Our Ref: LU/397/21/DOC

Approval of details reserved by condition imposed under LU/134/21/PL relating to conditions 3-details of the new external doors and windows including sections and their treatments along with details of new porches; 4-details of proposed removal of existing unsympathetic modern windows and their replacement and re-use of existing traditional windows; 5-all new internal joinery such as doors and skirting boards; 6-details of proposed location, heights, materials and finishes of boundary treatments & 9-on site cycle parking storage.

The Farm 39 East Street Littlehampton BN17 6AU

Arun District Council have decided to **APPROVE IN PART details reserved by condition**

Block Plan 1:500

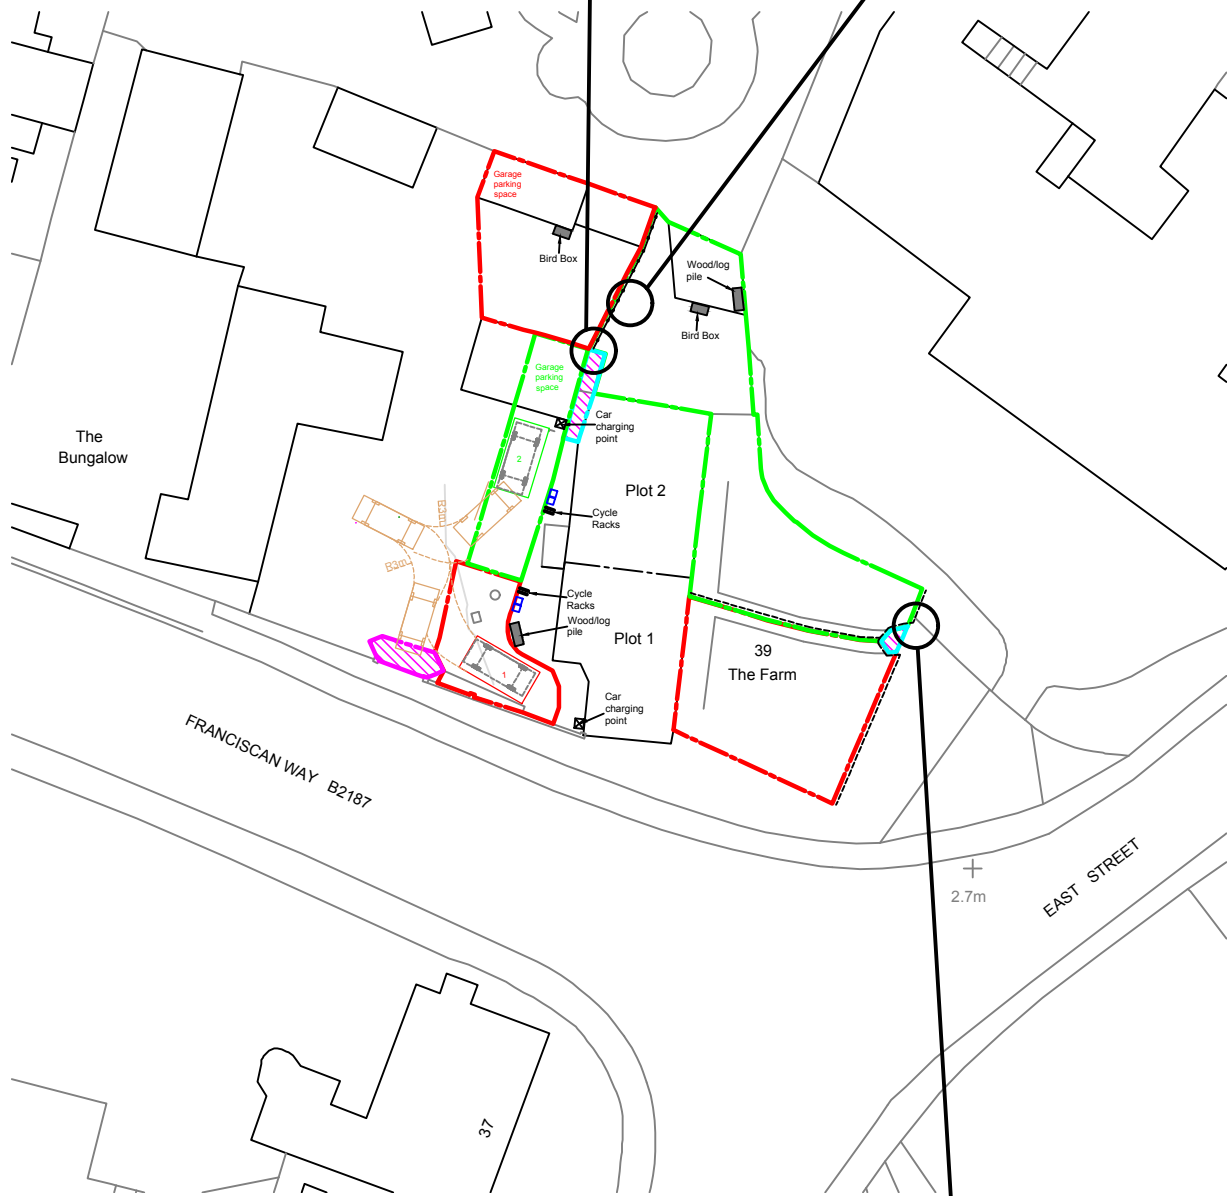
Further information with respect to condition 6 requiring the details of the proposed location, heights, materials and finishes of boundary treatment has been provided and accessed by ADC Principal Conservation Officer. With the exception of lack of details of the finish of the picket fence they are considered to be acceptable and the condition can be partly discharged.

The condition is partly discharged and when submitting revised application for refused conditions 3 & 4 confirmation of the finish of the picket fence can be made then.
